AB/29/21/L

78 Maltravers Street Arundel BN18 9DS

Listed building consent to replace windows 2 No. front and 1 No. rear windows. Replicas of existing design, with 4-4-4 ultra lite glazing, 3 No. box frames with sash.

Drawing
Typical detailed elevation
and section

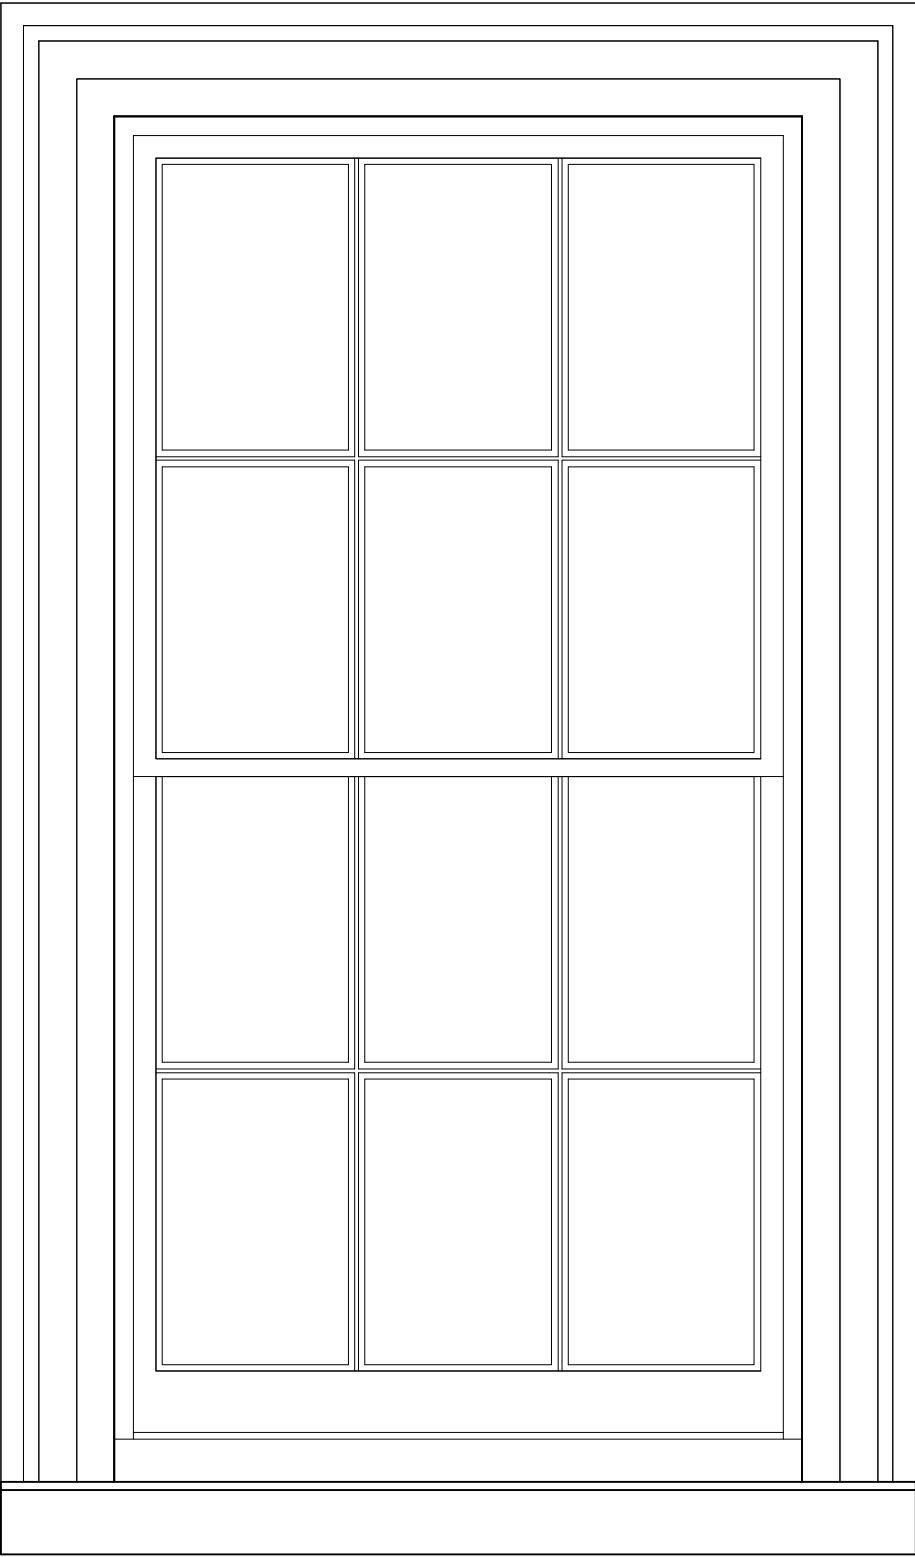
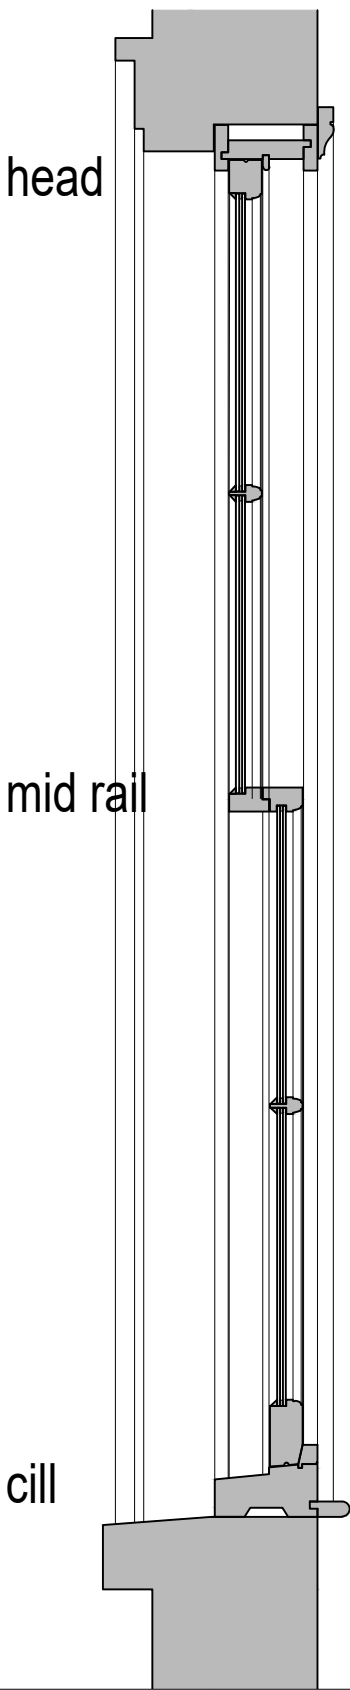
It can be the case that the replacement glazing requires the dimensions of the glazing bars to be increased. However, it is not clear if the replacement windows would be an exact like-for-like replacement in terms of dimensions, or if details such as the glazing bars have been increased in size. Details of the glazing bars and the existing dimensions of the windows have not been supplied. We would not want the replacement glazing/glazing bars to look different from the remainder of existing windows in this particular property, but also the other houses within the terrace. As a consequence, if you are minded to approve the application the applicant would have to submit a detailed drawing showing a large scale cross section and elevation of an existing and a proposed glazing bar in order to show how they exactly reflect the existing windows.

Further, it is not clear how the windows would be treated, and this should be confirmed if you are minded to approve the application. It is hoped that they would be painted the same colour as existing to reflect the existing terrace.
